Our ref: DOC19/935855
Senders ref: SSD 9874

Subject: Walla Walla Solar Farm – Environmental Impact Assessment

ATTACHMENT A BCD Assessment Summary for Walla Walla Solar Farm Environmental Impact Statement (SSD 9874)

ATTACHMENT B Detailed comments for Walla Walla Solar Farm Environmental Impact Statement (SSD 9874)

Indicative Fence Flood Gate

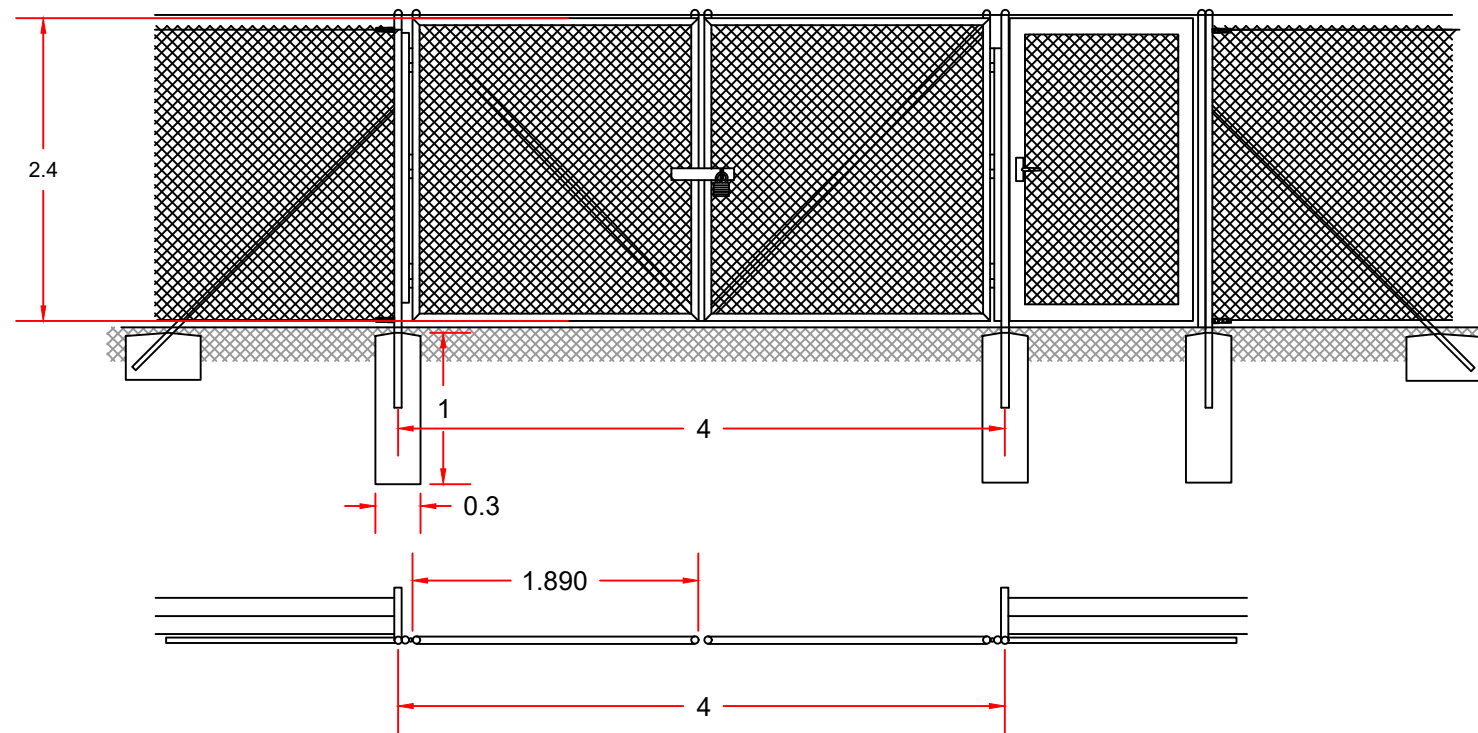
A digital version of development footprint shown on Figure 6-1 (page 79) has not been provided. Shapefiles do not indicate the 10 m asset protection zone (APZ) and setbacks outside the security fence that are described in the EIS (Section 7.4.2, page 264). For example, **Attachment C** to this review shows the mapped location of the security fencing as being less than 10 m from vegetation to be retained.

- Provide a complete map of elements of the proposal as described in the EIS, including water tanks, materials lay-down areas, screening plantings and asset protection zones associated with the security fence, and confirm that they have been included in the assessment.
- Supply all digital data required by the BAM, including a digital version of the development footprint as shown on Figure 6-1 (page 79) with a 10 m asset protection zone outside the security fence.
